ACCESS REPORT

DEVELOPMENT APPLICATION

25-27 GEORGE STREET, THE ROCKS SYDNEY

1st December 2017

Drawing No.
SSDA 102

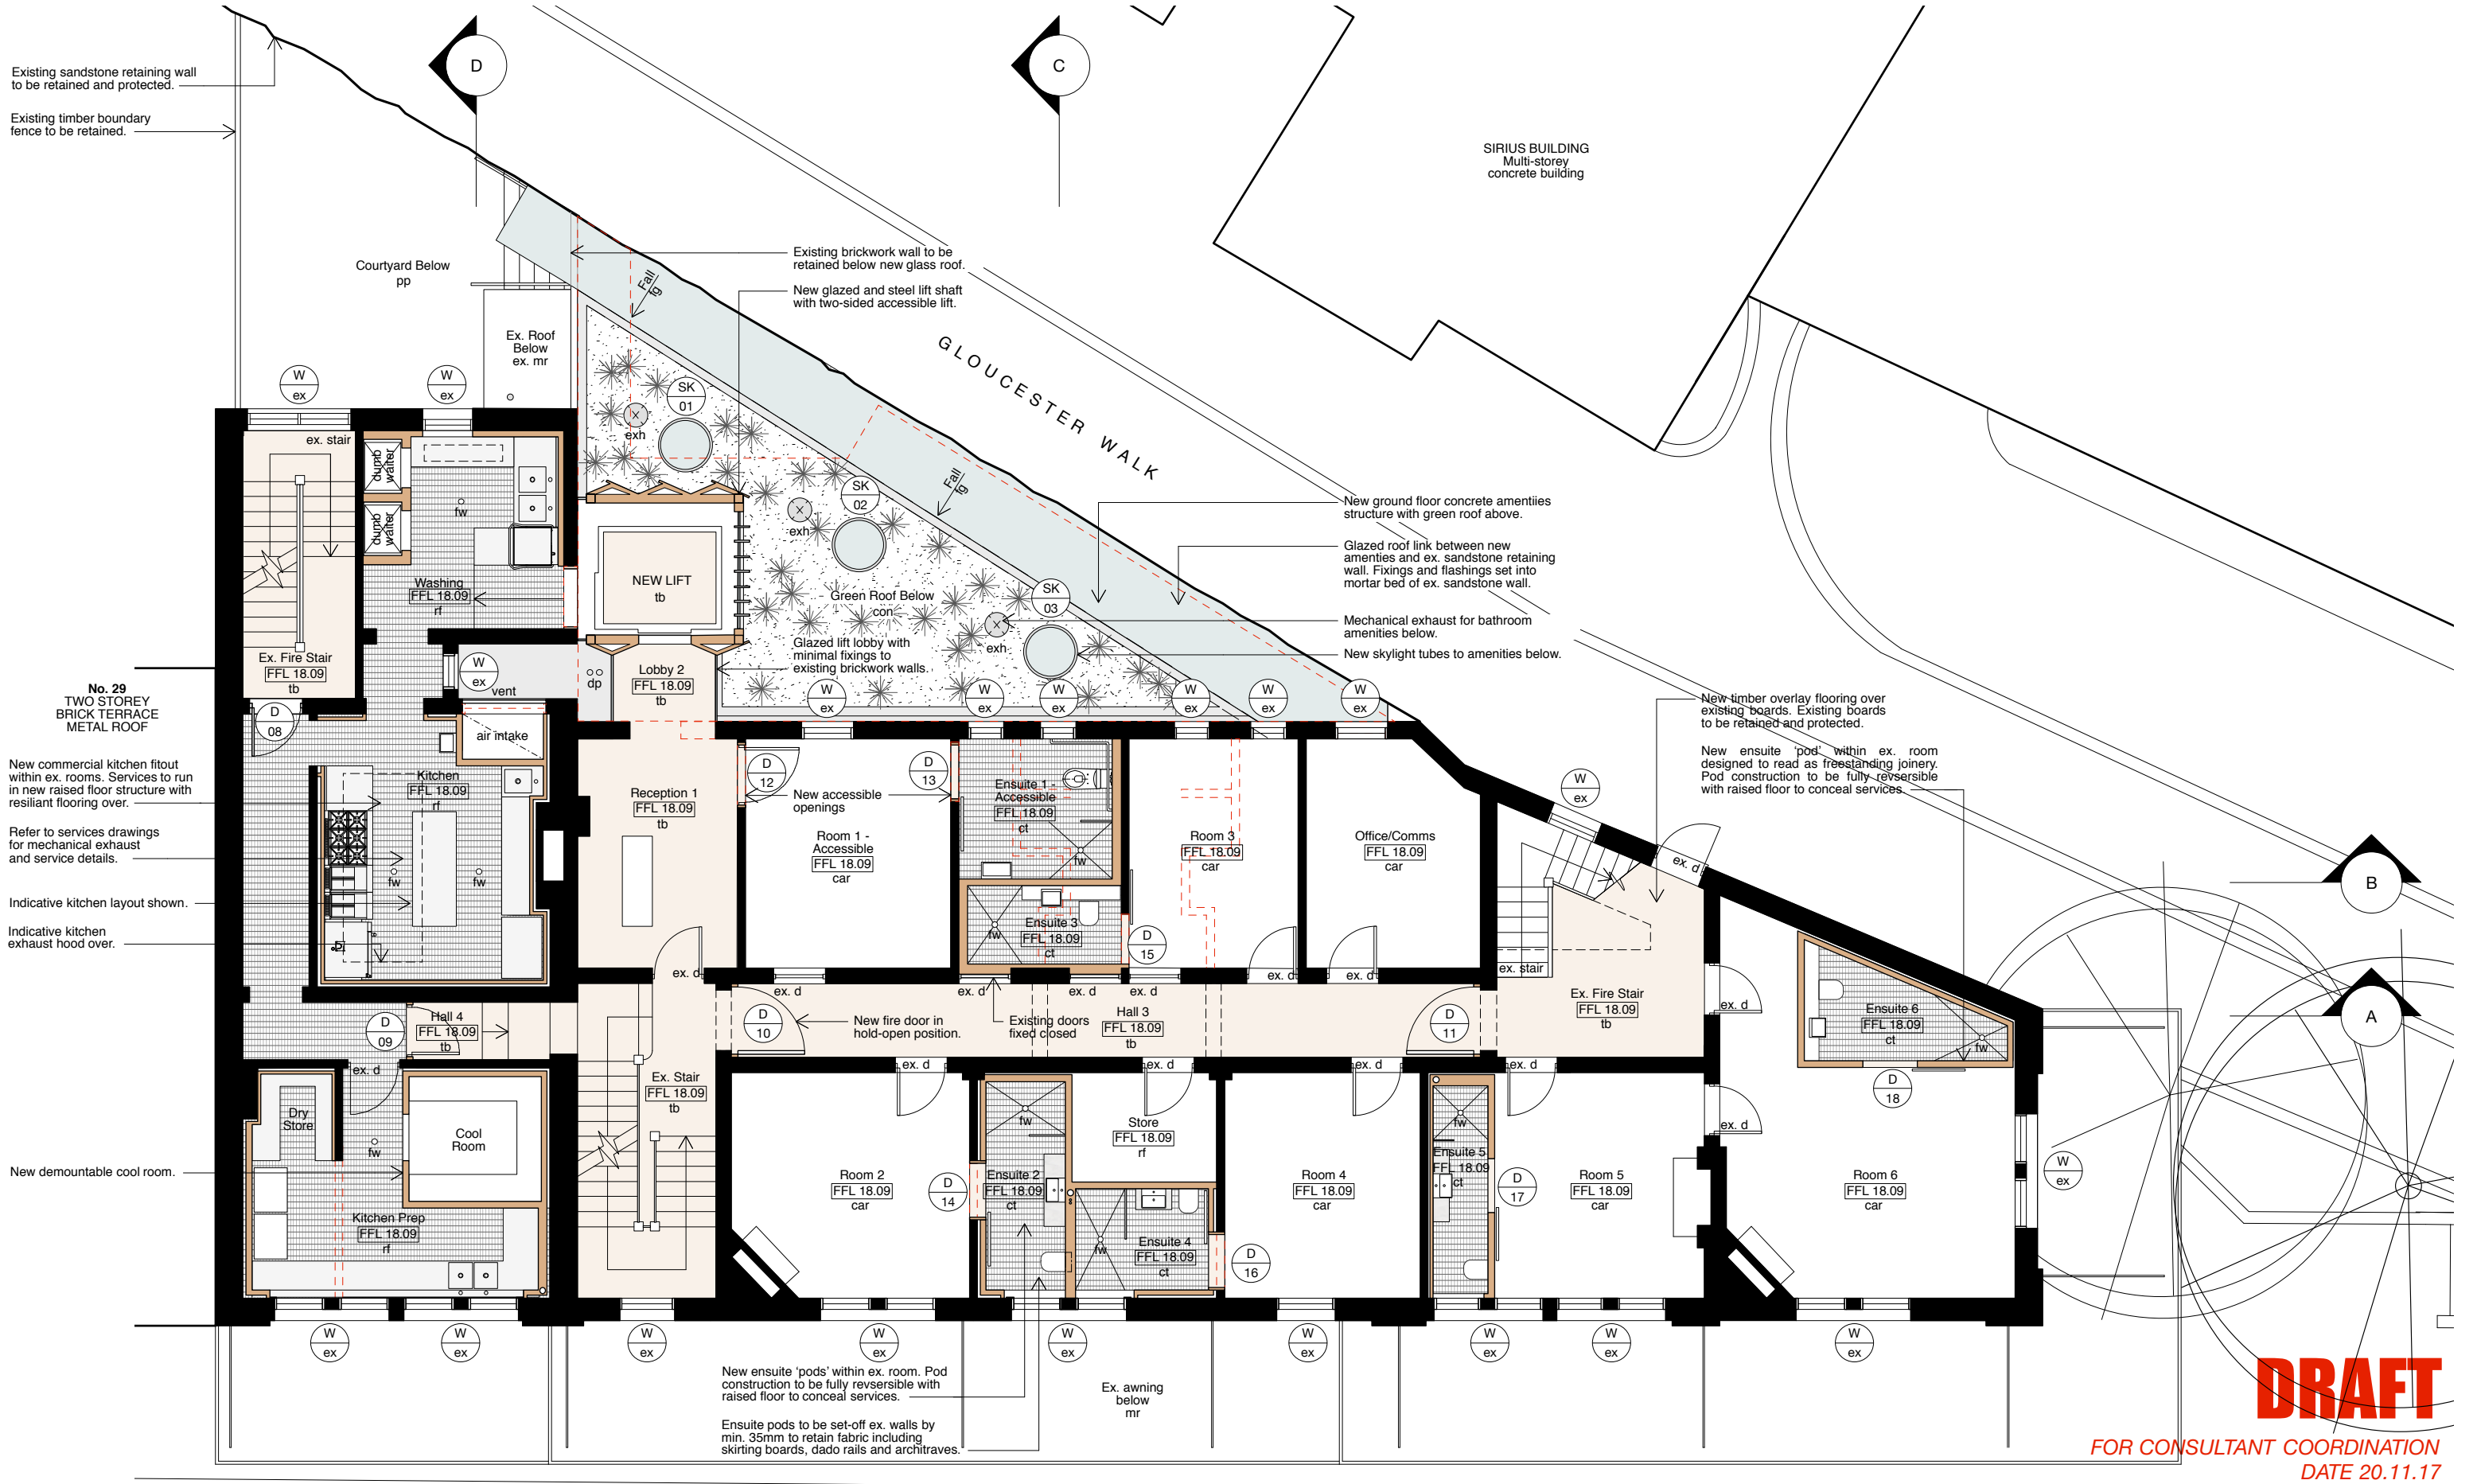
BCA / DDA Access Code Review		Complies
GROUND FLOOR		
4. Internal Access: Ground Floor - Within the ground floor area of the hotel the plans show a split floor level with a lift and stairway providing access between the levels of the lounge bar / bistro / dining areas and sanitary facilities to ensure equitable access to satisfy Part D3.3 of the BCA, DDA Premises Standards.		YES

5. The new lift proposes a dual doorway to enable access to split floor levels. The lift landings provide adequate area for turning and passing consistent with AS1428.1 and E3.5 of the BCA and DDA Premises Standards.		YES

6. The plans indicate a 1600 X 1400mm lift car which facilitates adequate space to facilitate a turn to enter and turn exit the lift in a forward direction for added convenience.		YES

7. The bistro and courtyard stairways will also include 50-75mm width colour contrasting step nosings, tactile ground surface indicators and other features in accordance with AS1428.1 / AS1428.4.1 to satisfy Parts D3.3 and D3.8 of the BCA and DDA Premises Standards.		YES at CC stage

8. Bistro & Courtyard - The circulation spaces within the ground floor bistro provide appropriate access for Turning, Passing and to the courtyard doorways which include a 920mm door and level thresholds to ensure equitable access to satisfy Part D3.3 of the BCA and DDA Premises Standards.		YES

BCA / DDA Access Code Review	Complies
<p>35. Accessible Toilet – The plans show a unisex accessible toilet on the ground floor that is 2500mm X 1900mm and will be documented at construction certificate stage to provide a 2650mm X 1900mm minimum area and internal fittings and fixtures to comply with AS1428.1 to satisfy Part F2.4 of the BCA, DDA</p>	 <p>Can Comply at CC stage</p>

Drawing No.
SSDA 103

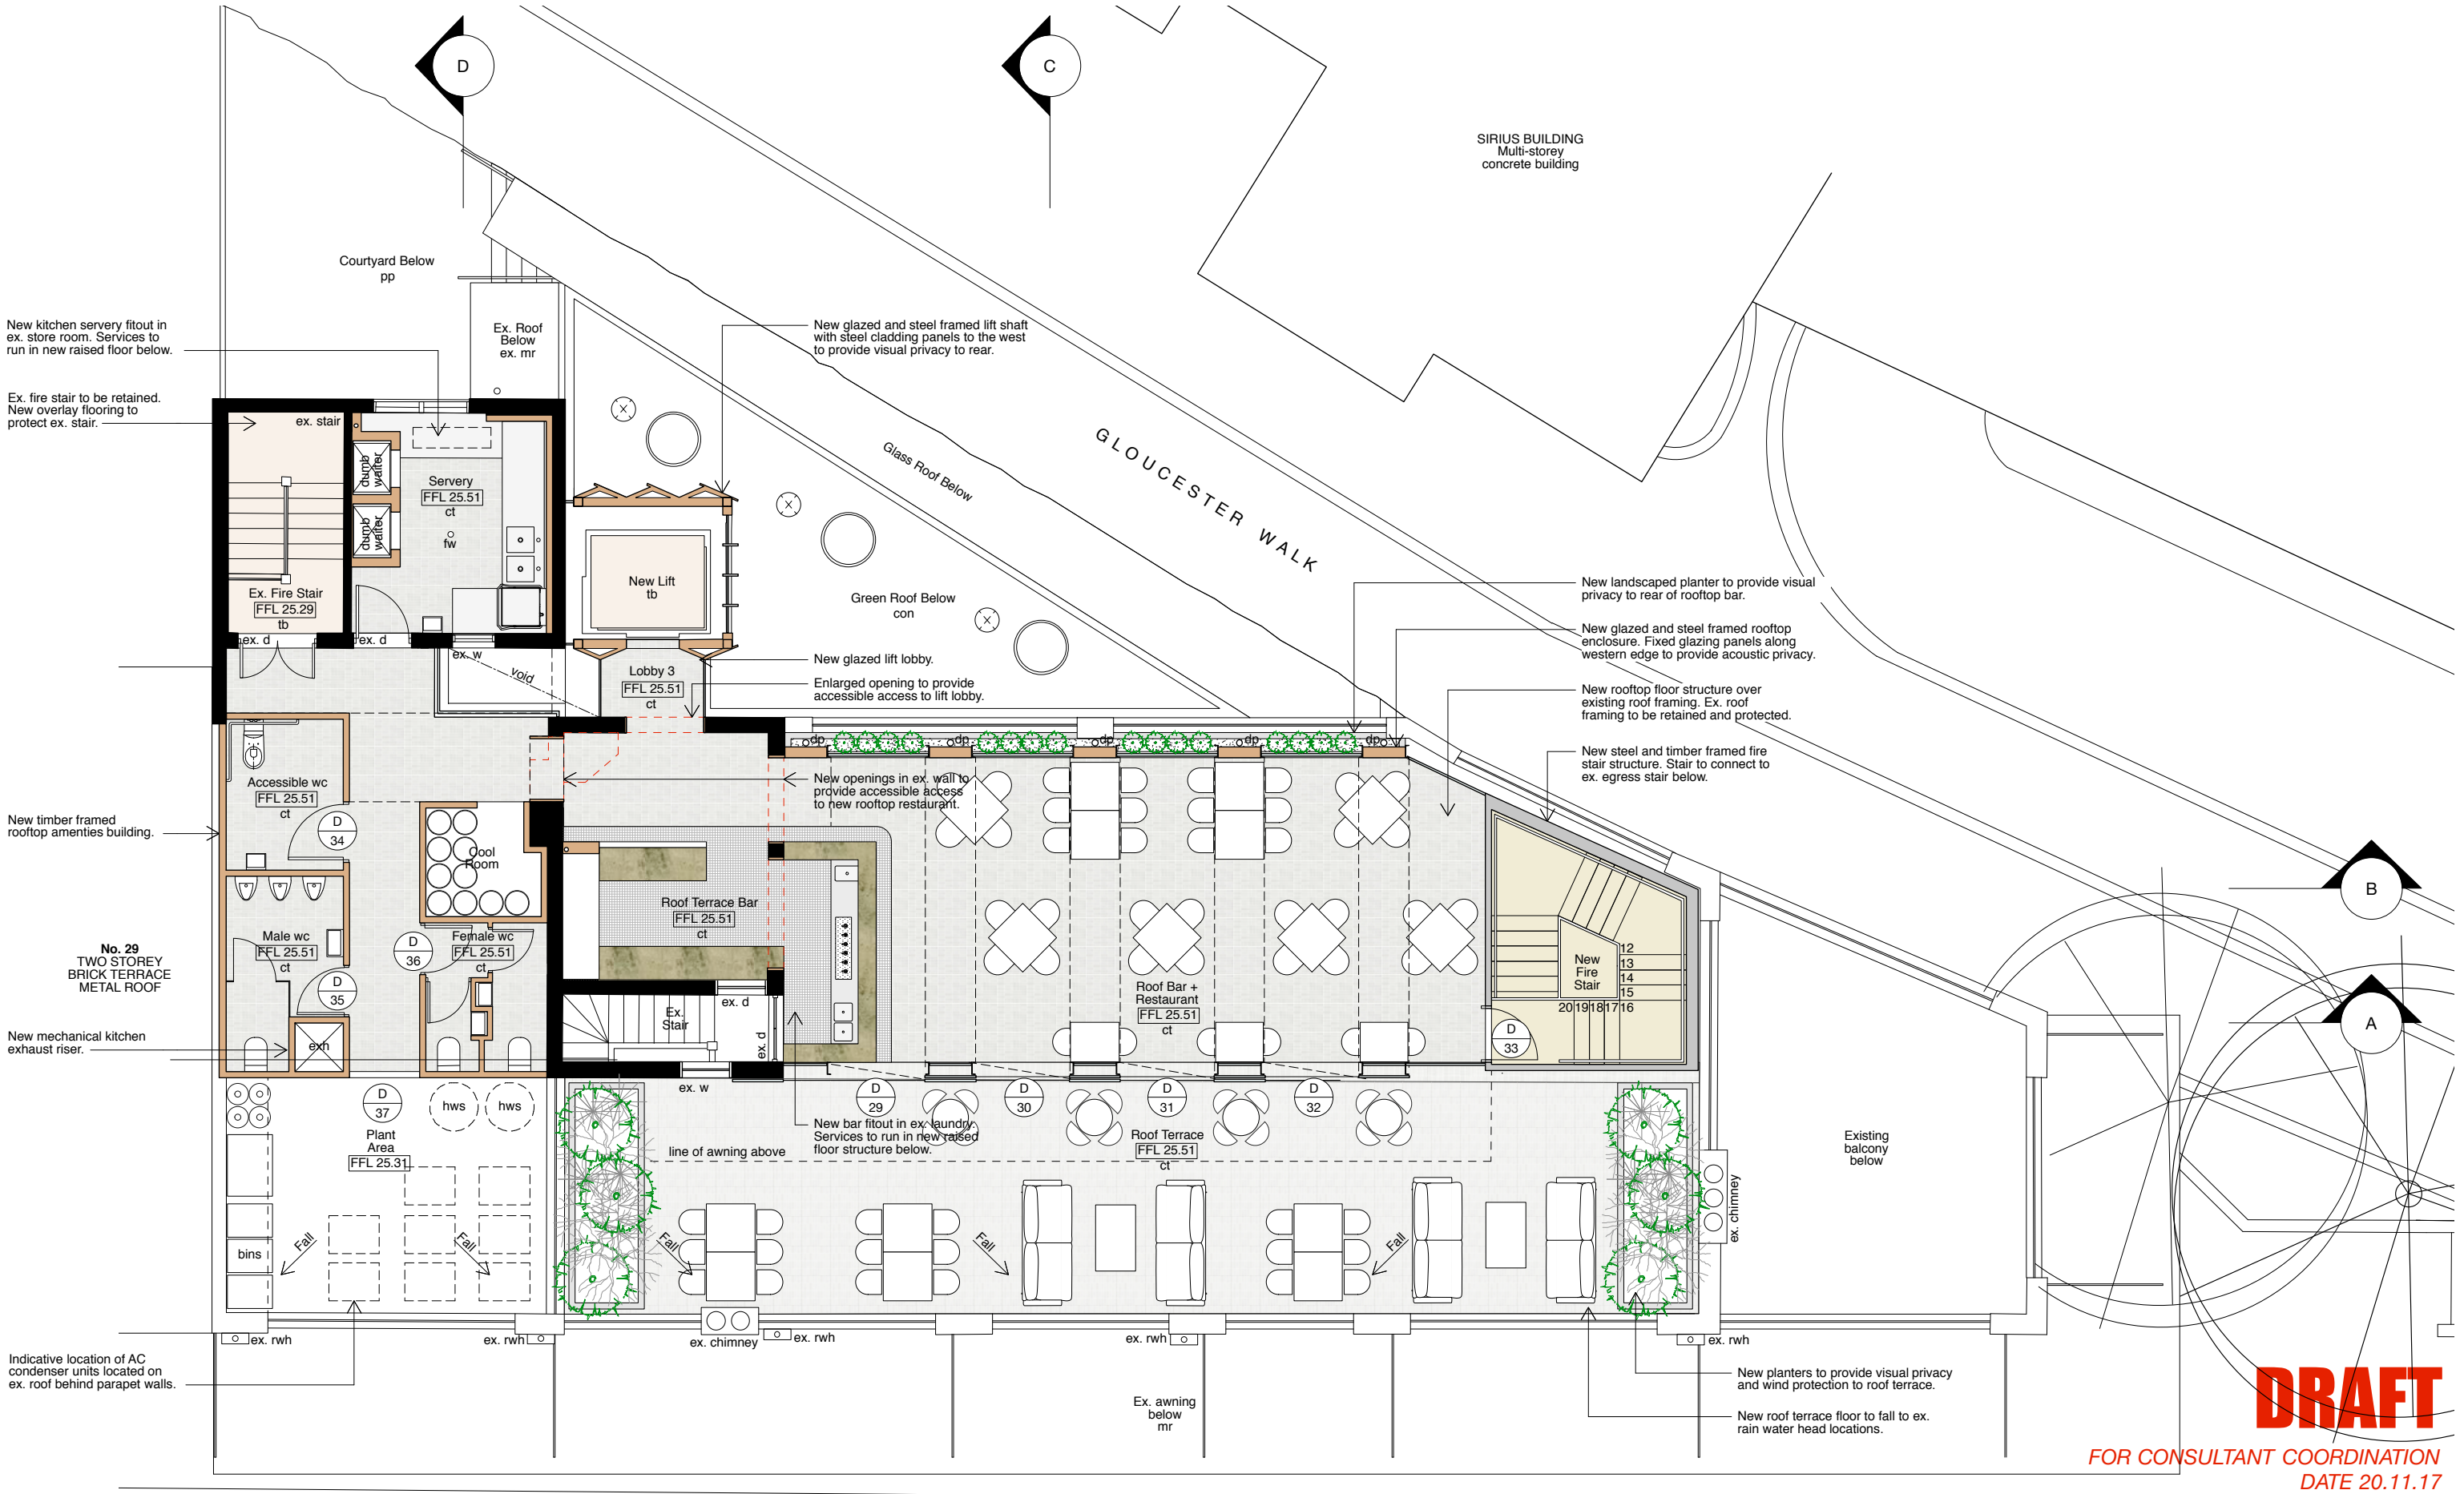
Ground Floor Dual Access	First Floor Dual Access	Second Floor Dual Access	Roof Terrace	
FIRST FLOOR				
<p>15. Internal Access: – Access from the lift to the reception desk and the Accessible Suite No. 1 provides adequate access for Turning and Passing Areas to comply with AS1428.1 and satisfy Part D3.3 of the BCA and DDA Premises Standards.</p> <p>16. The remainder of the first floor structure and layout of rooms is existing and no new works are proposed due to the heritage significance of the premises, with exception of;</p> <ul style="list-style-type: none">a) Demolition of two partition walls and four (4) doorway openings.b) Installation of bathroom pods for the 6 accommodation suites, coolroom and other fitout items of the commercial kitchen which are generally free-standing of the structural walls.				<p>YES</p> <p>N/a</p>

<p>17. Notwithstanding the minimal intervention on the first floor, retention of the central corridor and limited access for people who use a wheelchair beyond the reception it is my opinion that the overall provision of the new lift and Accessible suite No. 1 readily complies with Part D3.3 and DPI of the BCA and DDA Premises Standards.</p>				<p>YES</p>
